Our Ref: FG/26/20/HH
Your Ref:

Town & Country Planning Act 1990 (as amended)
Town & Country Planning (Development Management Procedure) (England) Order 2015
Application for Planning Permission for Works or Extension to a Dwelling

Development Two storey side extension, part two storey part single storey rear extension, single storey front extension and porch to front.
Location 27 Meadow Way Ferring

rev	description		date	scale	project	27, Meadow Way Ferring Block Plan
				1:200		
				@ A4		
				drawing number		
A	Side extension to No 29 added	310816		TSH/MW/005		
dm		app		rev.		
date		date		A

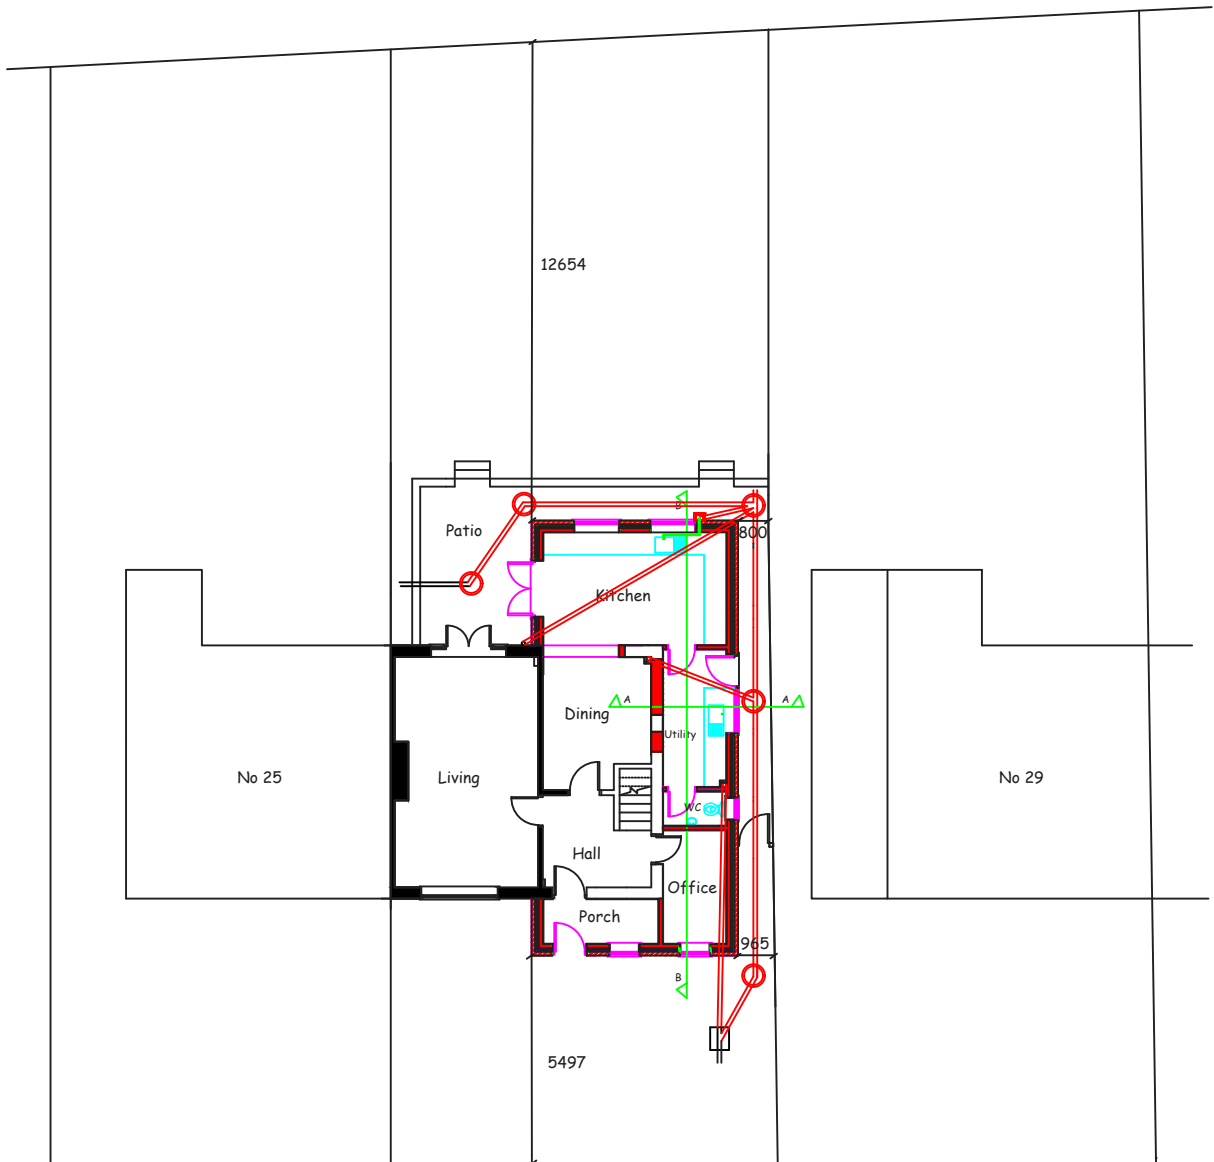
Block Plan: You are required to include dimensions from the proposed extensions to all site boundaries.

27, Meadow Way, Ferring, West Sussex, BN12 5LD

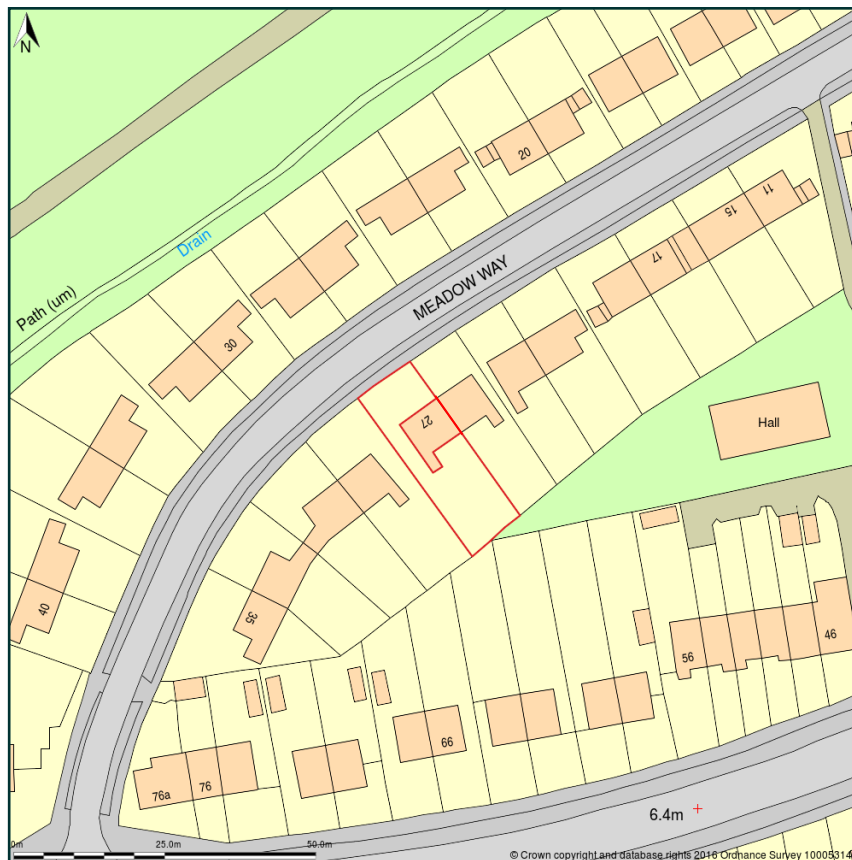
Location Plan: You are required to outline the site to which the proposal relates in a solid red outline.
